13 March 2018

**Response to Submissions – Section 4.55 Modification Application – SSD 6724 MOD 3
60-78 Regent Street, Redfern**

LEVEL 01 PLAN

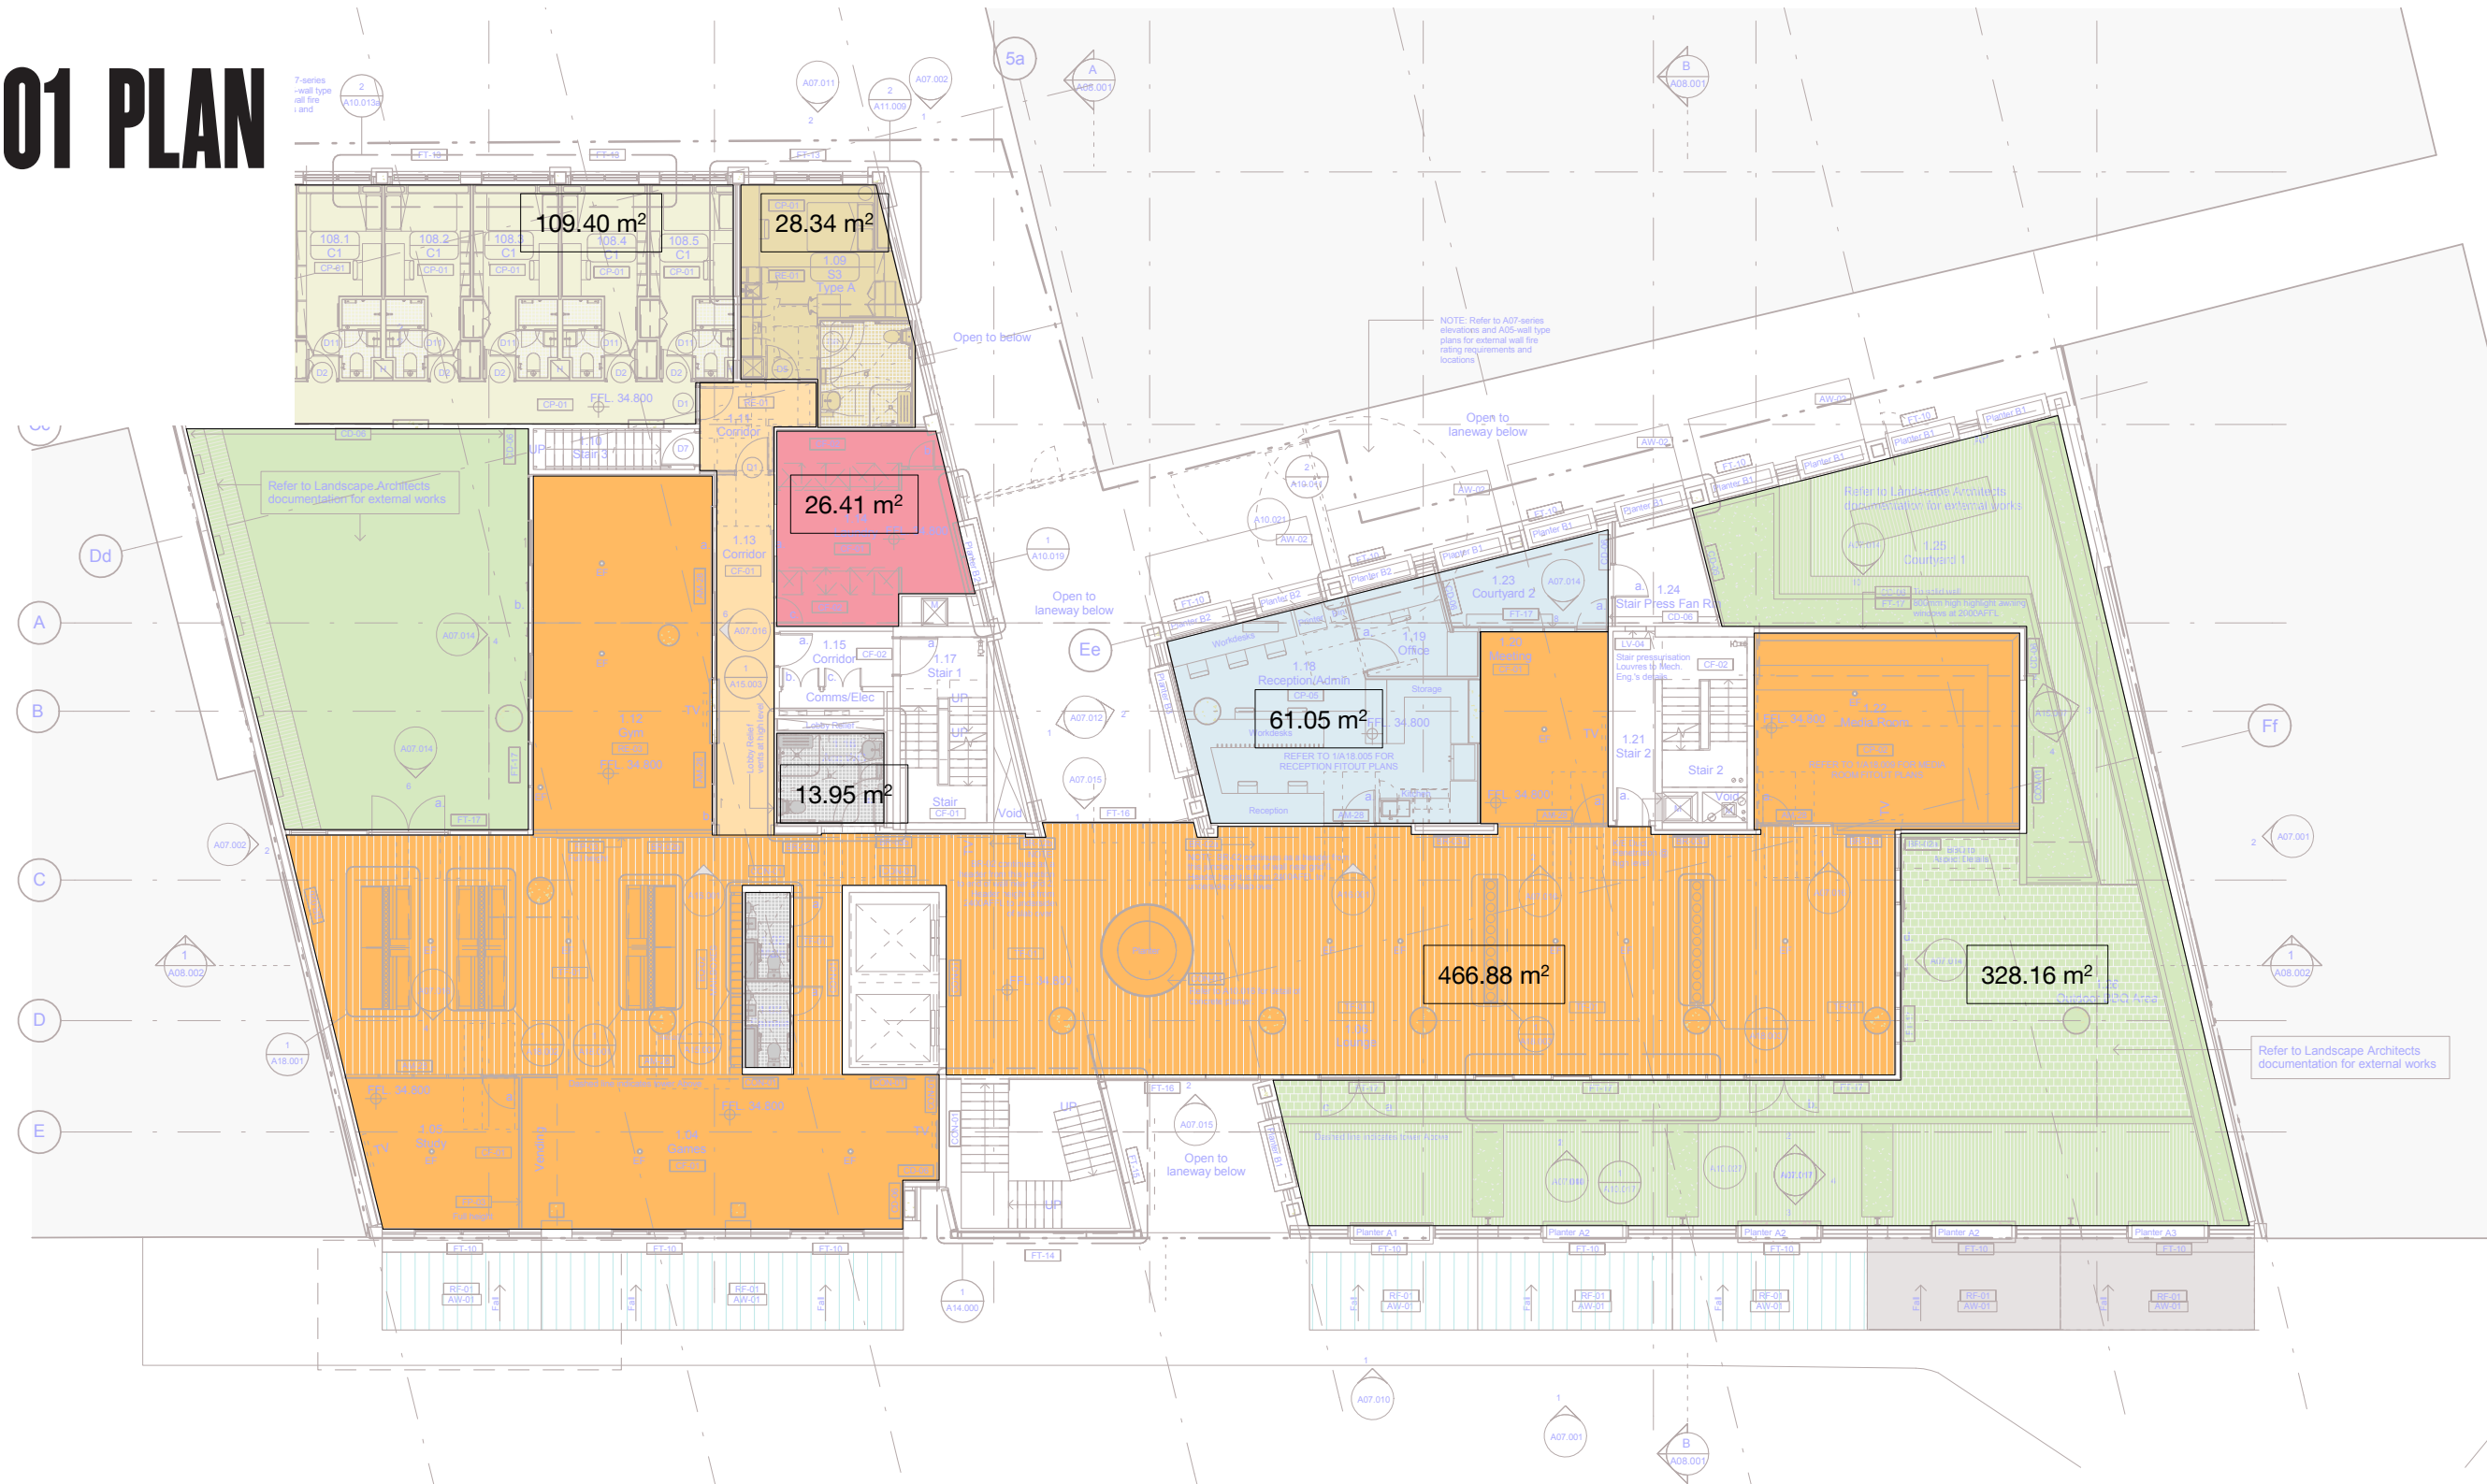
We note that Council's submission confirms that the room size of the studios complies with the City of Sydney Development Control Plan 2012 (DCP) minimum size requirements for two occupants.

Table 1 below sets out a schedule of all communal indoor spaces provided within the approved and constructed facility. This includes the Level 1 communal area, as well as communal areas provided for cluster units. Measured plans supporting these calculations are provided at **Attachment A**. Based on these calculations a total of 1,160.8m² of internal communal space is provided, or 2.55m² per occupant which is well in excess of the 1.25m² DCP control.

*Cluster bedrooms provide communal dining and lounge areas (included) and kitchen areas (excluded) in a combined space. Accordingly, a 1-metre wide area from the edge of the kitchen has been excluded from the communal area calculations as demonstrated at **Attachment A**.*
